Your ref:
Our ref: 23/00967/F
Please ask for: Mrs Lesley Raby
Direct dial: 01553 616818
E-mail: borough.planning@west-norfolk.gov.uk

Details: **Small rear extension and minor window and door alterations to a previously approved planning consent 22/00649/F at 4 Green Lane Thornham Norfolk PE36 6NQ**

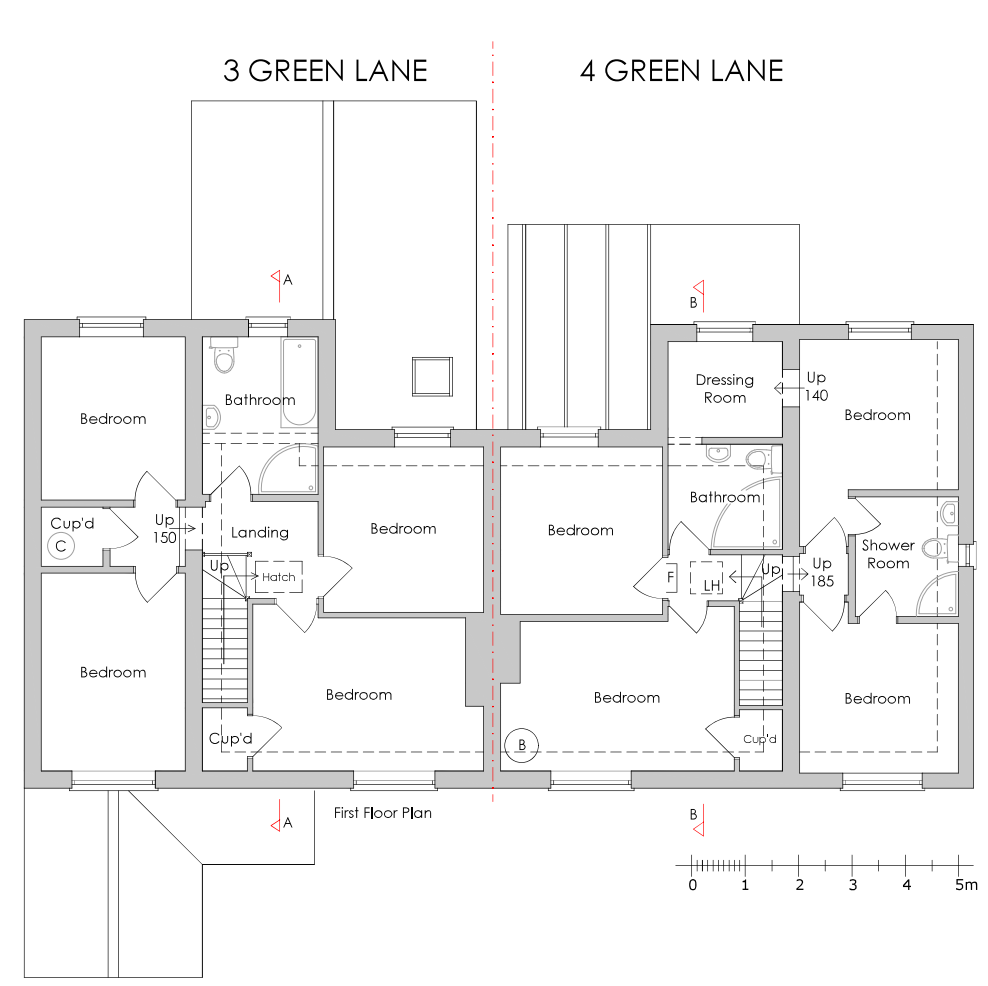
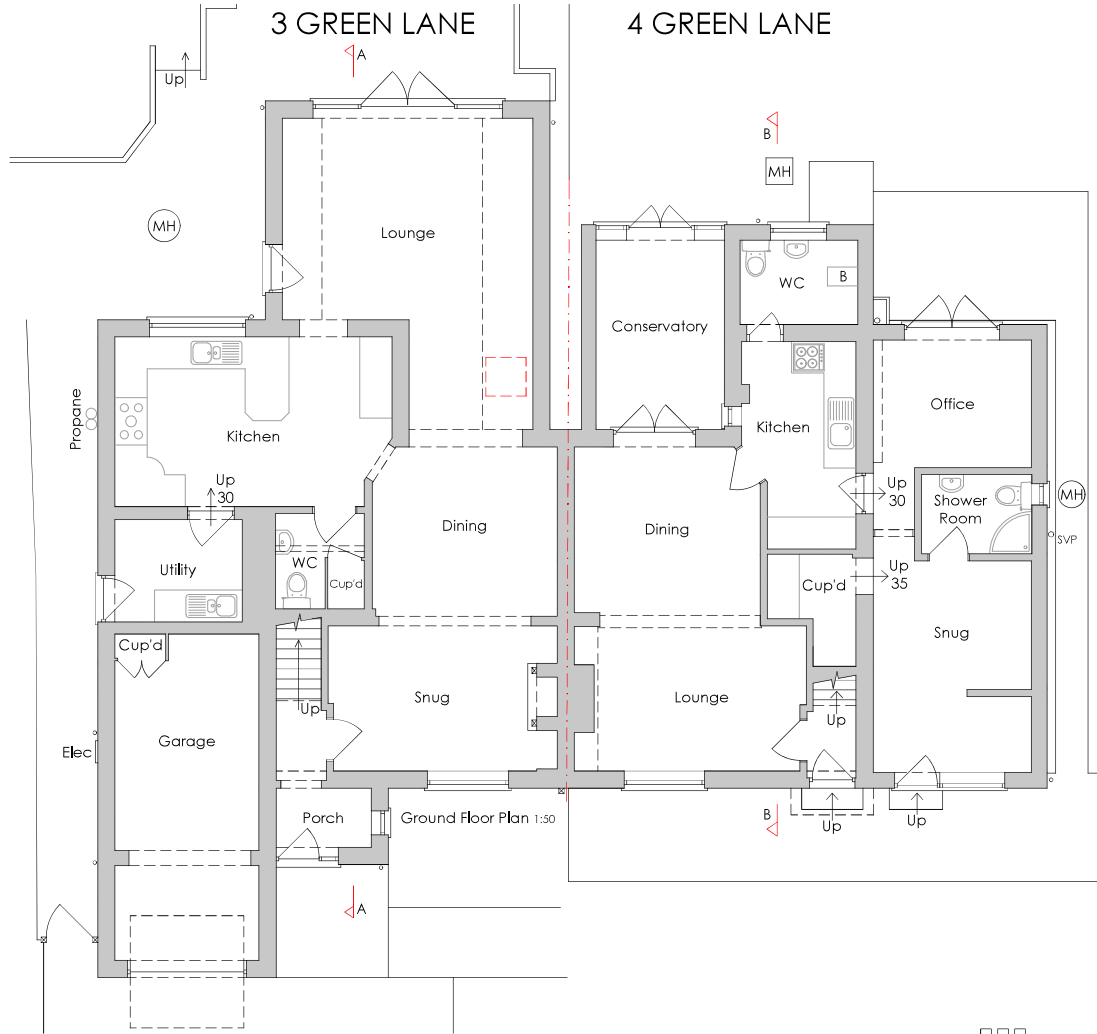
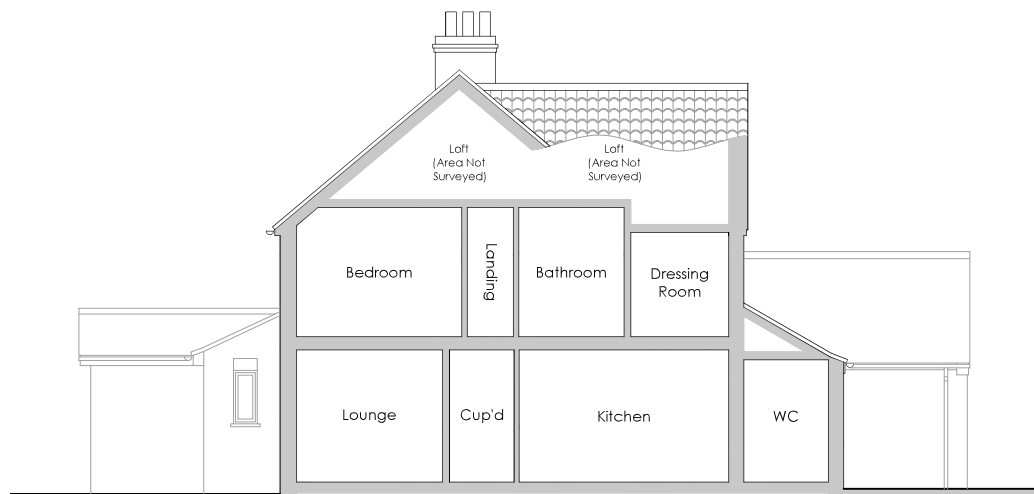
1. Show the position of the roof lights on the floor plan and show the position of the air source heat pump on the elevation.
